TOWN AND COUNTRY PLANNING ACT 1990

Reference: H13-0847-20 **Date of Decision:** 11th December 2020
Applicant: Mr J Hook
The Anchor Inn
280 Bridge Road
Sutton Bridge
Spalding
PE12 9SH
Location: Rear Of 46 Seas End Road Moulton Seas End Spalding
Description: Erection of 2 detached dwellings

South Holland District Council hereby give notice that this application has been REFUSED for the above proposal for the following reason(s):

SITE PLAN 1:200

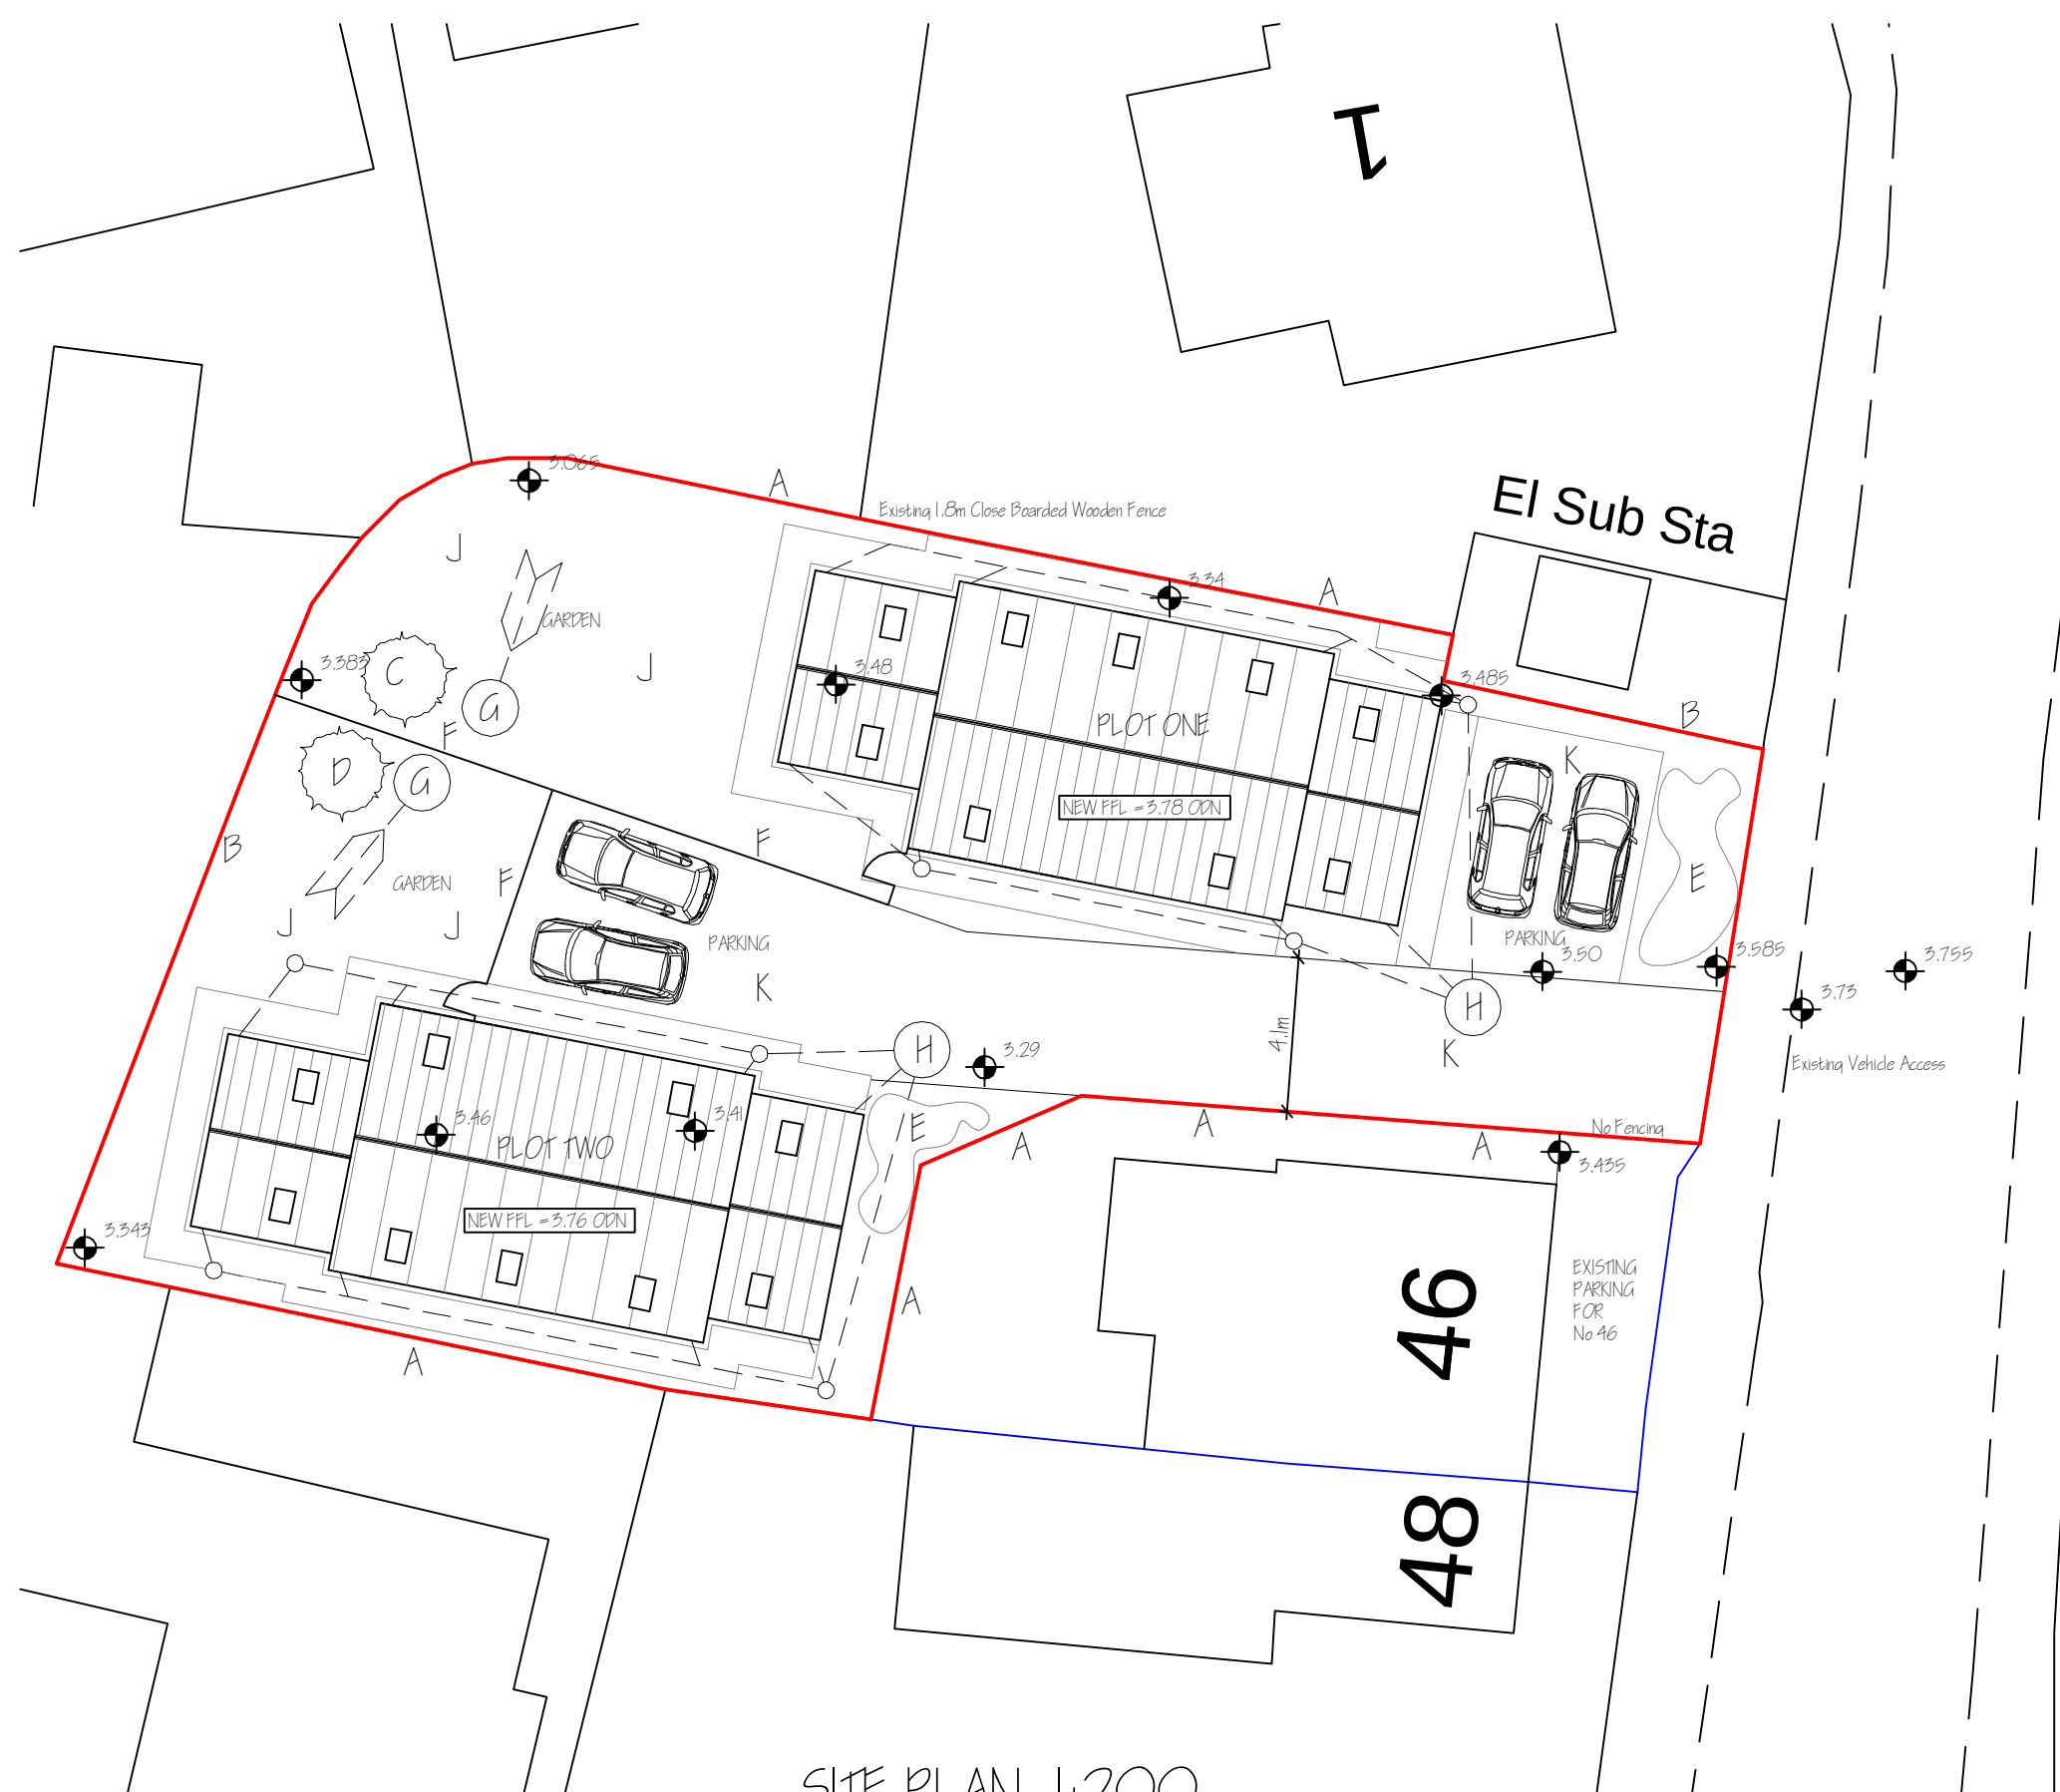
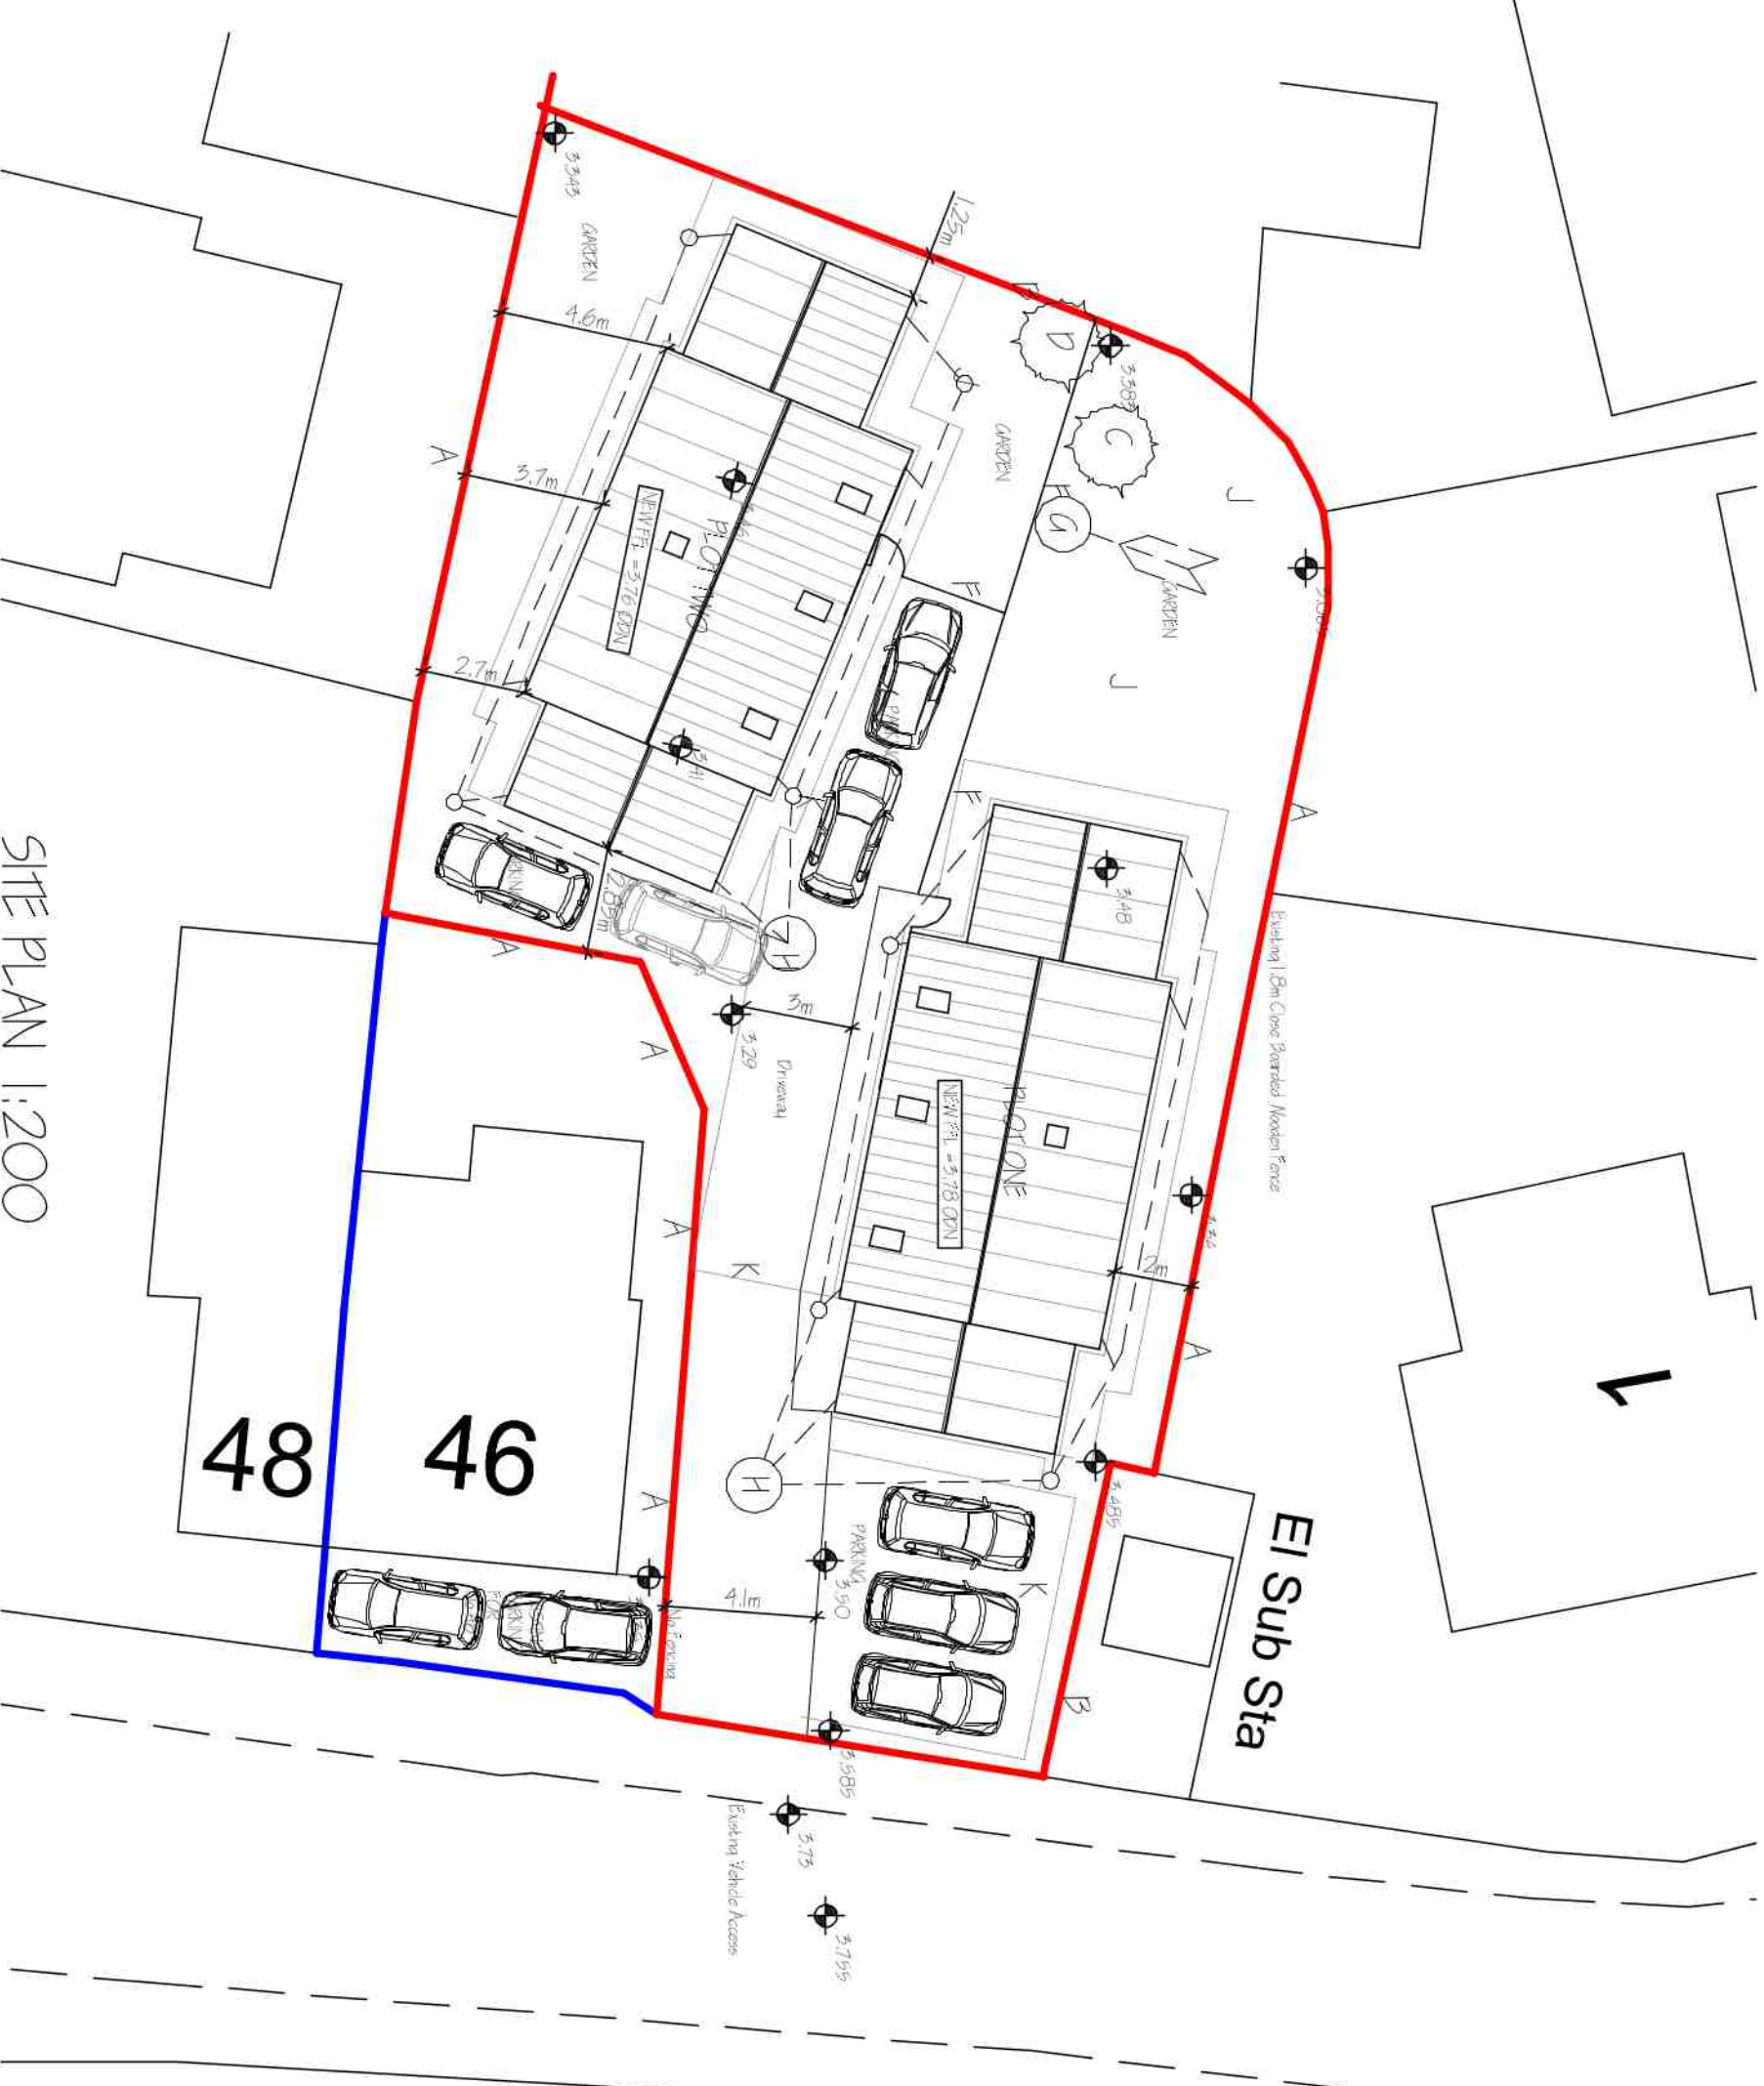
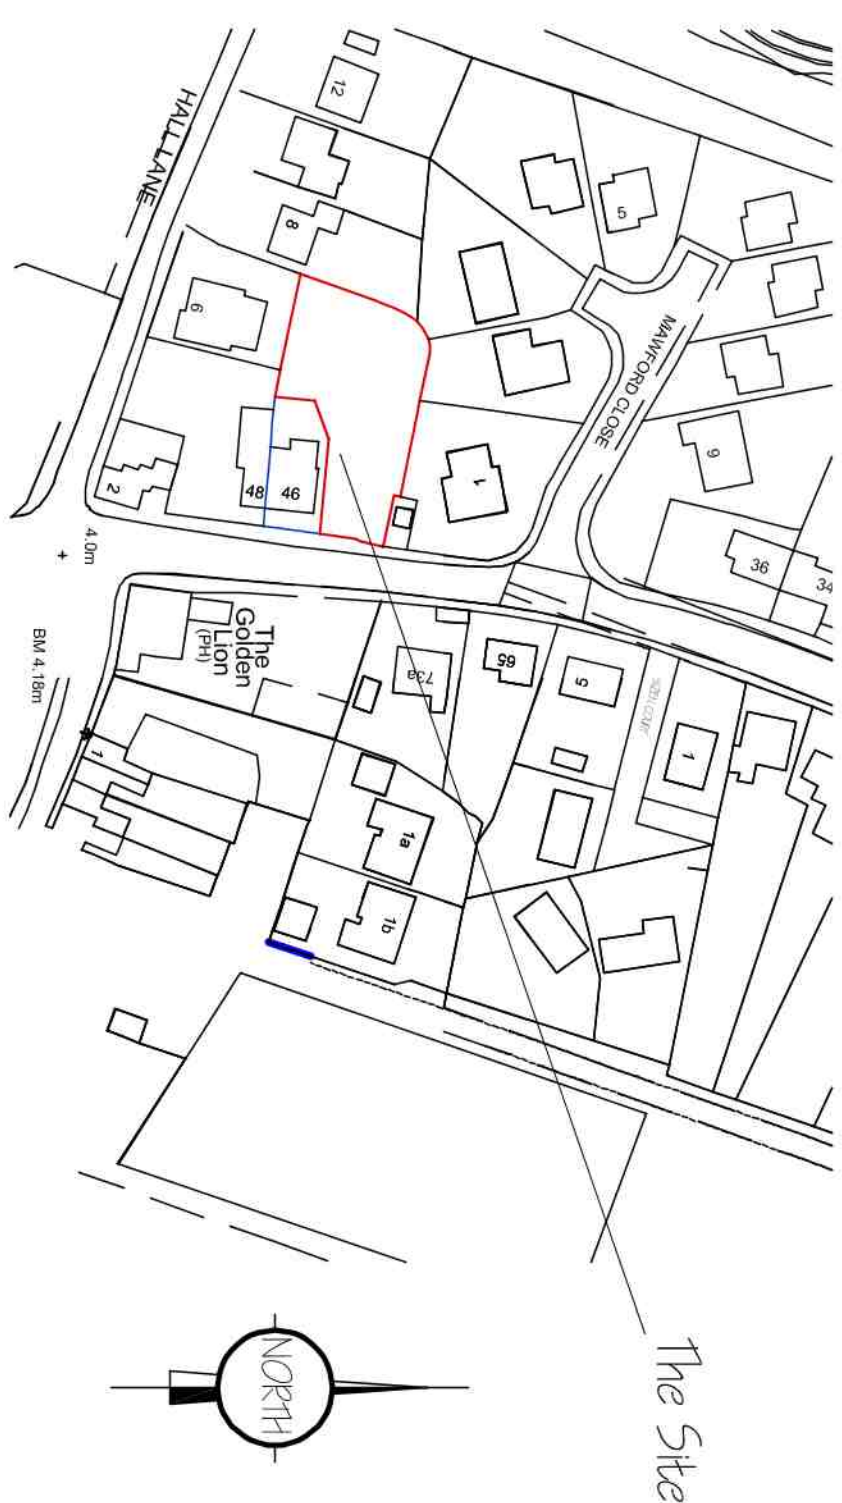
- 1 The scale of the proposed dwellings would result in a form of development that is visually cramped and dominated by building, hardstanding and boundary treatments (at the rear) and would negatively impact upon the character of the area.

- 2 Taking into account the separation distance between the rear elevation of Plot 2 and the rear elevation of no. 6 Hall Lane, it is considered that there will be a material adverse impact on the outlook of occupants from the rear.

Furthermore, there are also issues of overlooking as well as minimal and seemingly unfunctional areas of external amenity space attributed to Plot 2.
